Application No: Y/76/20/A
Site Address: Land to the South of Ford Lane and East of North End Road Yapton
Description of works: Construction of 9 No. flags and 2 No. mounted stack advertisement boards to eastern side of North End Road.

Thank you for your internet representation made on 21st September 2020 which has been recorded as an objection with the comments as follows:

| Drawing Title  | North End Advertising Plan |              |             |

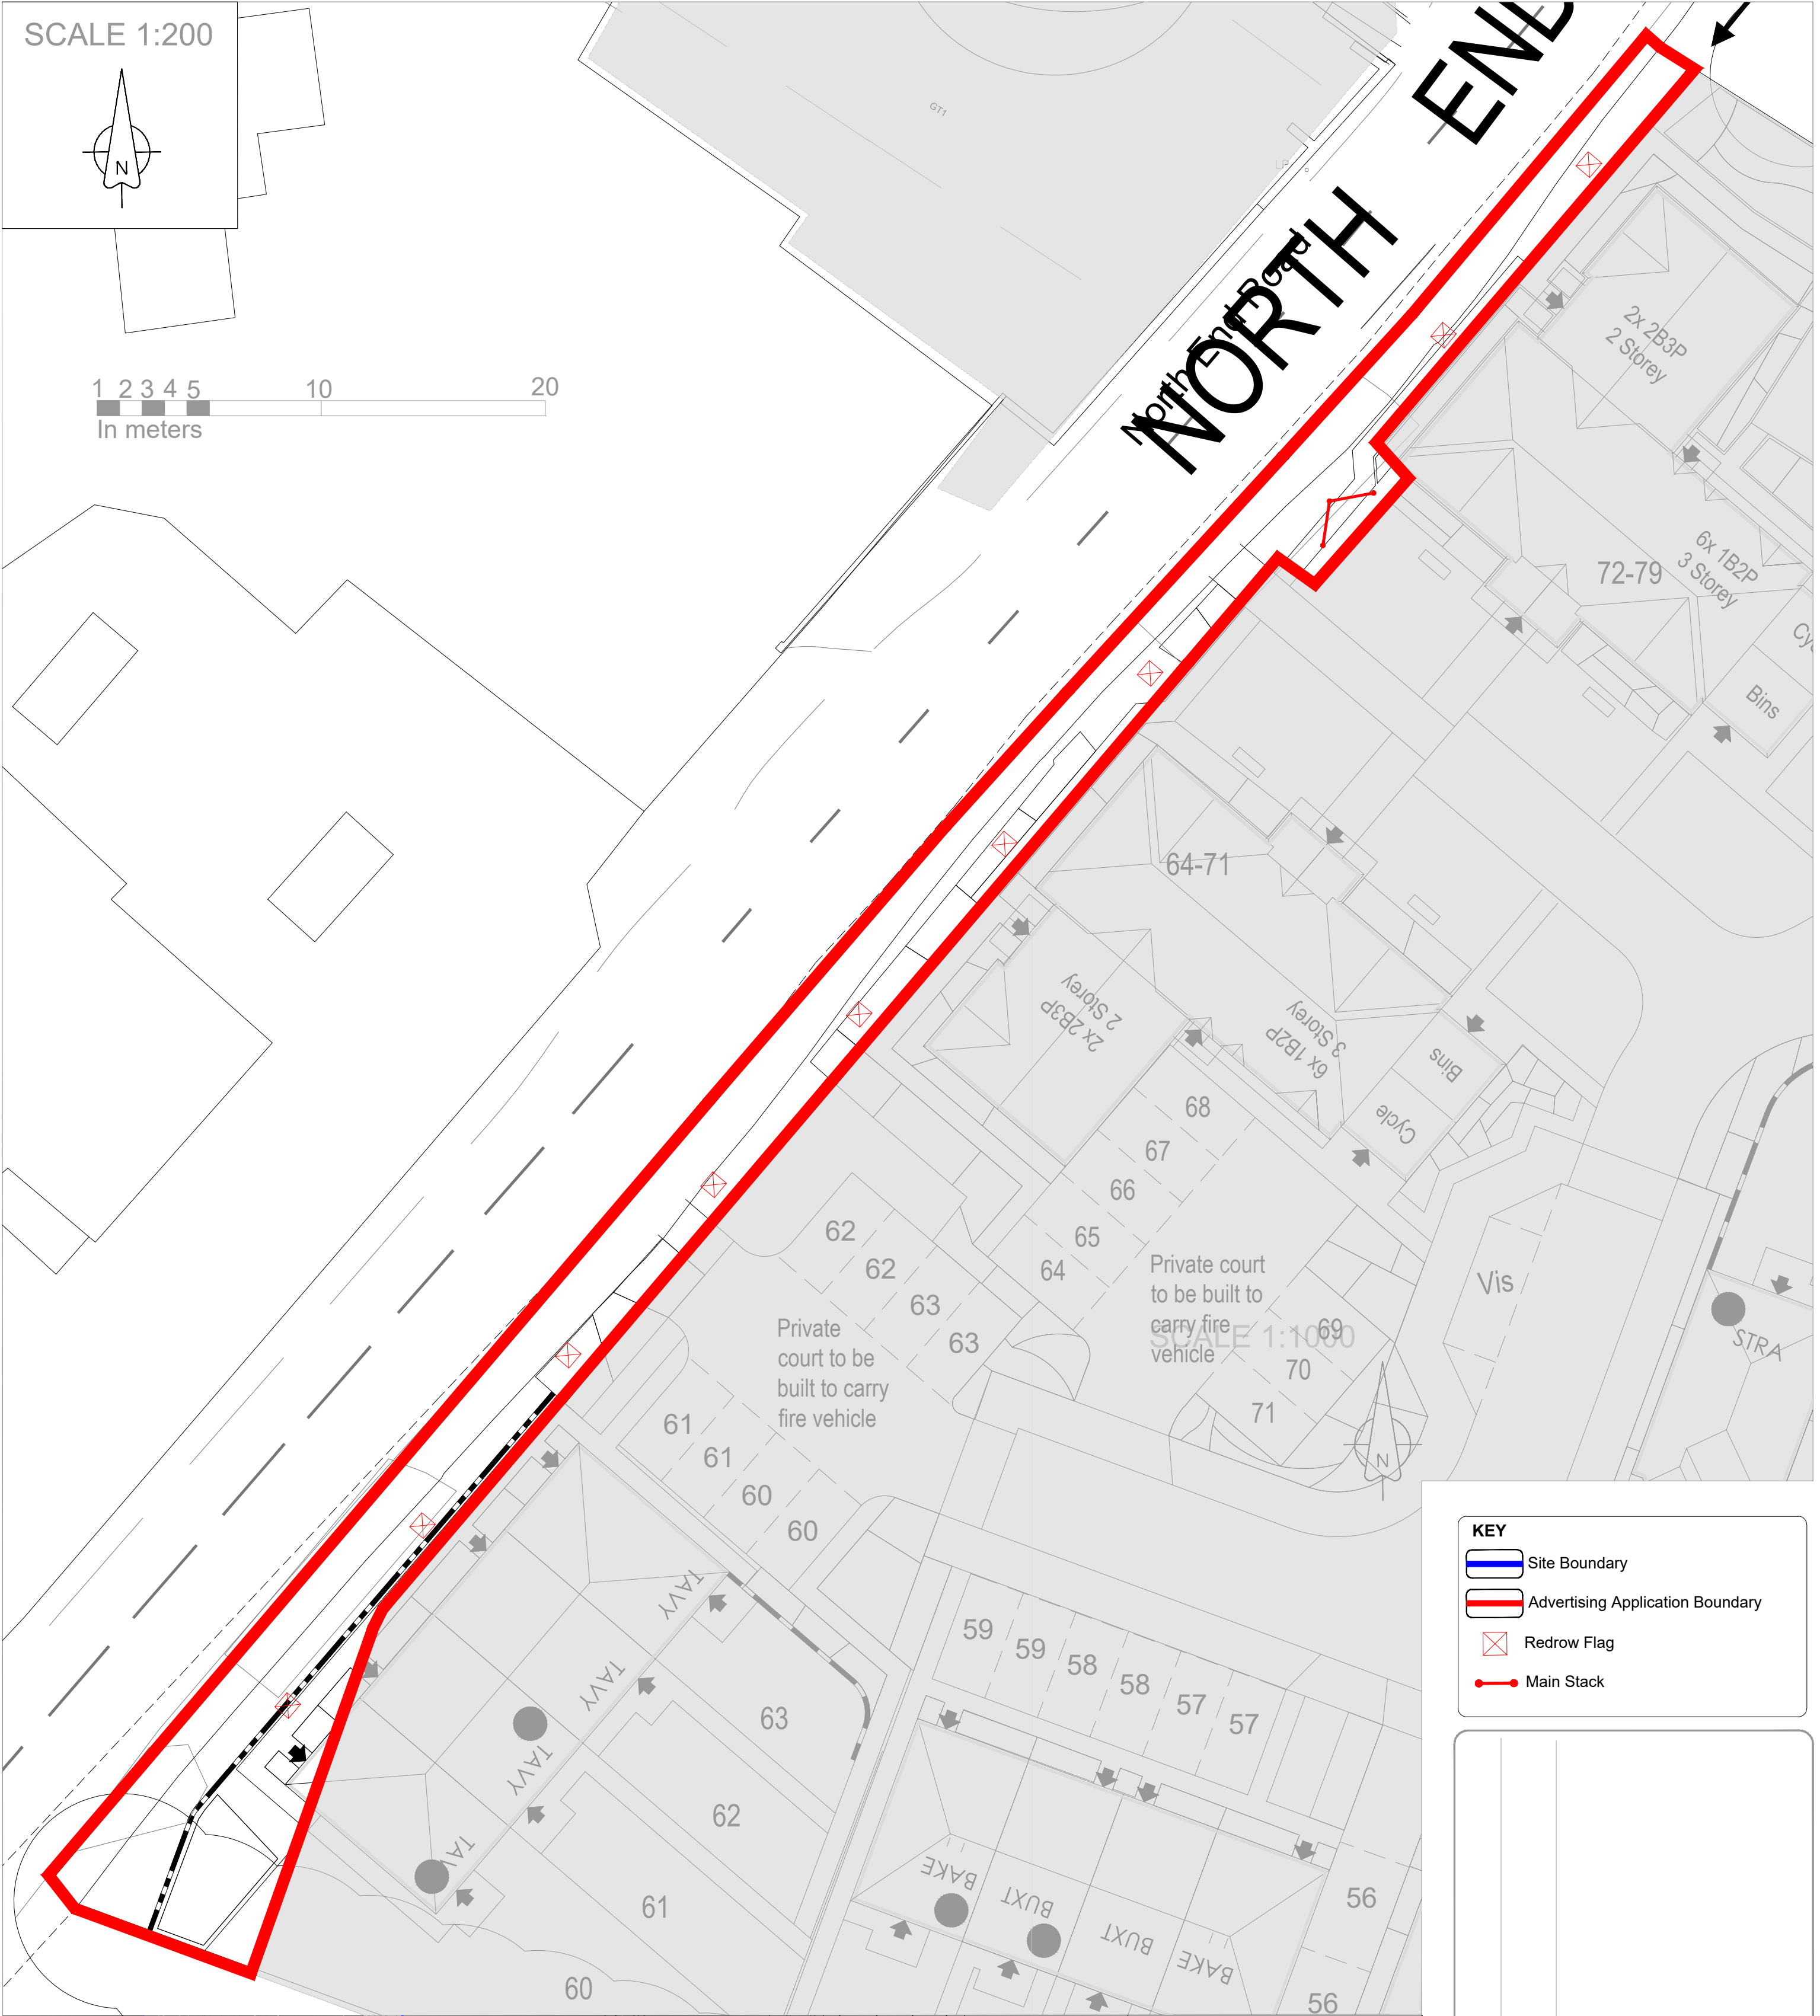
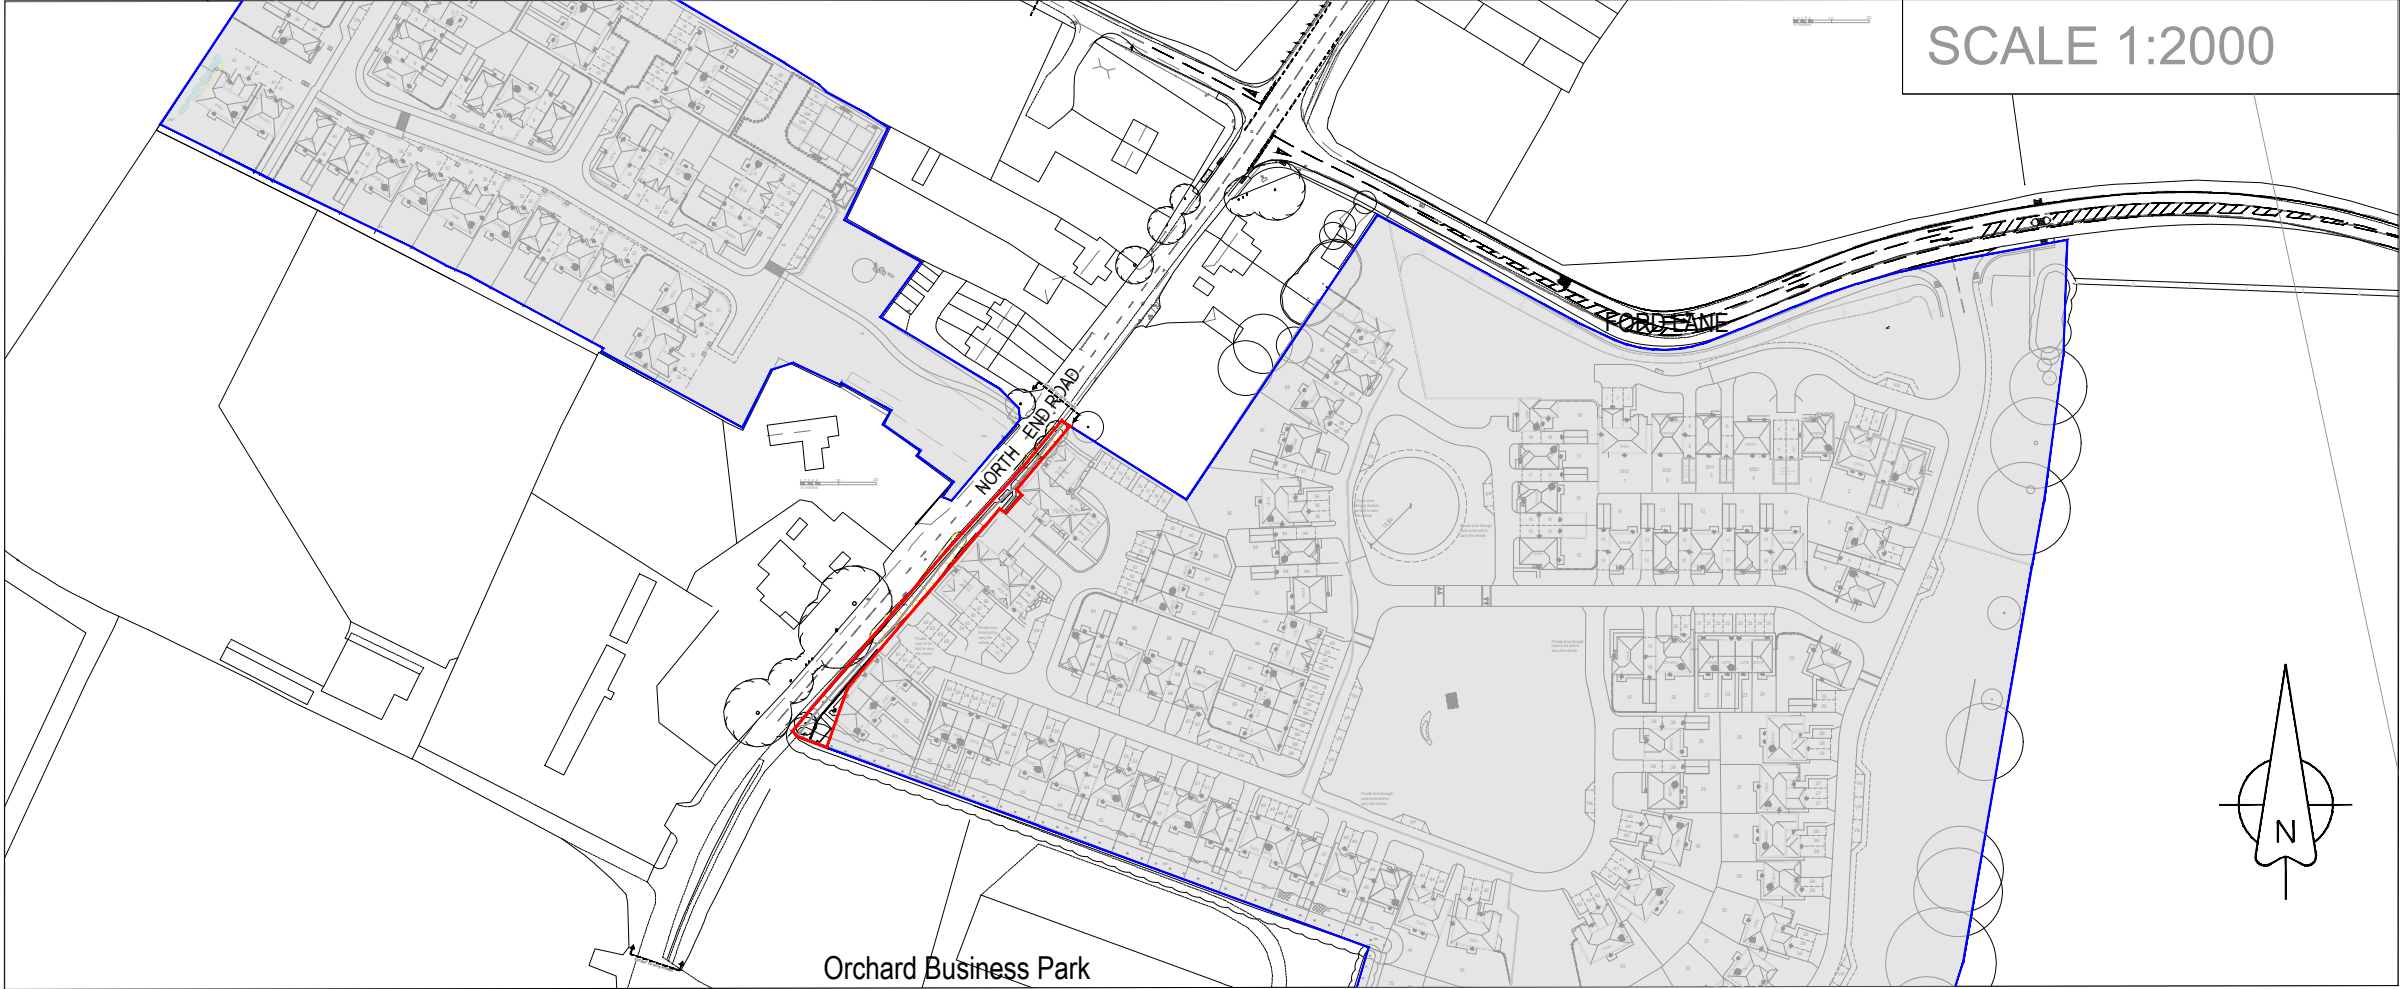
YPC has fully considered the above application and whilst fully appreciating the commercial need to market and enhance a development believe that the proposed level of advertising material to be excessive. YPC have great concerns that the number of flags will simply constitute unnecessary cluttering of the streetscape and detract from the site's rural setting. YPC would therefore request that the number of flags be reduced to a more sympathetic number which will still make the public aware of the new housing scheme but not detract from the rural setting.

YPC strongly object to the use of 9 marketing flags especially where the applicant will also have 2 substantial advertisement signs. However, YPC would be prepared to reconsider its position should the number of flags be reduced to 2.
